Date 29th October 2019

RE: Land west of New Barn Lane, Bersted, PO21 5DN

Thank you for your correspondence of 1st October 2019, advising me of a planning application for the 'Approval of reserved matters following the grant of BE/77/16/OUT and BE/40/18/PL for 50 No. residential units with associated roads, drainage & other related infrastructure' at the above location, for which you seek advice from a crime prevention viewpoint.

Plots

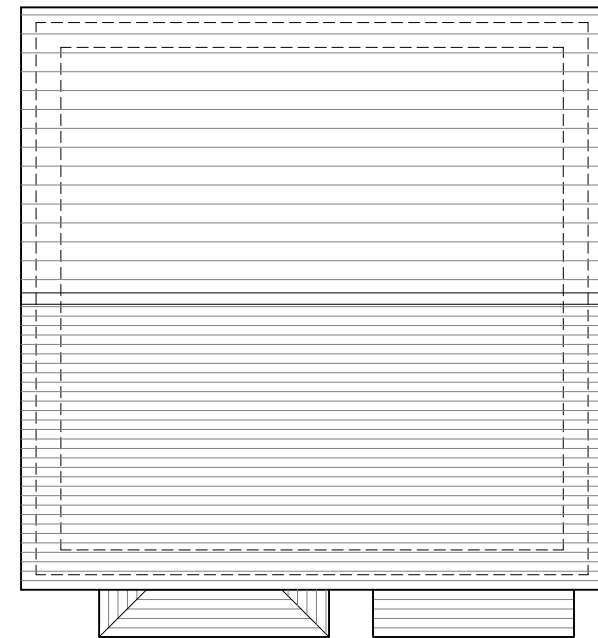
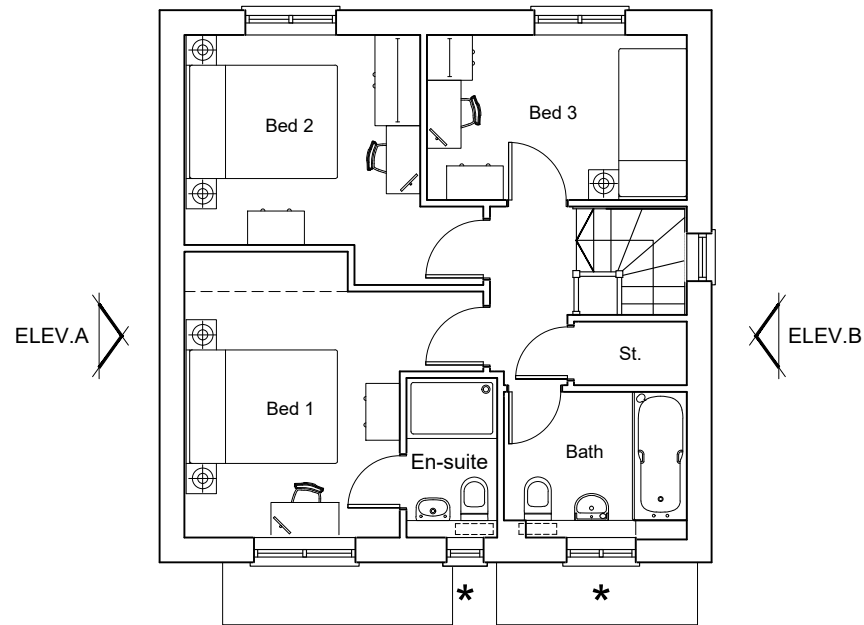
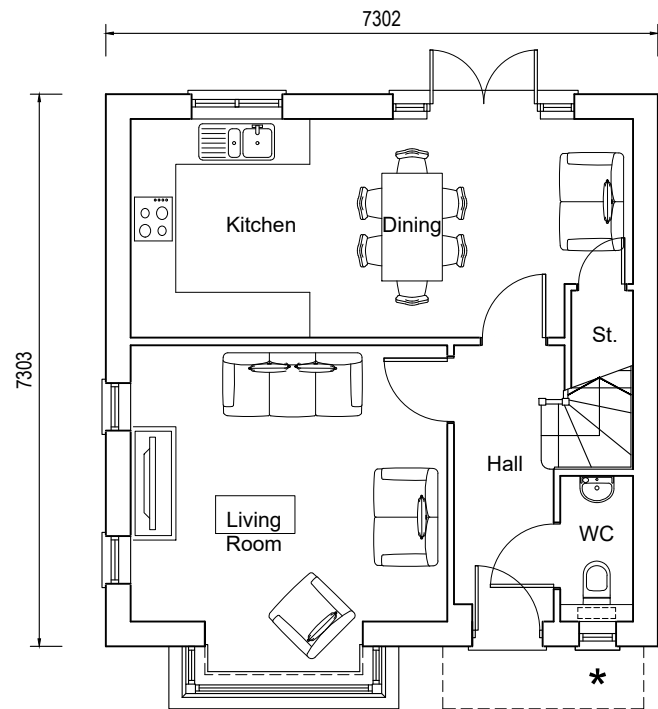
The visitor parking bay to the south east of plot 26 may be difficult to view due to the perimeter fencing of that plot obstructing the visibility of it, unless the dwelling has a gable ended window. There are no residential dwellings opposite to provide surveillance.
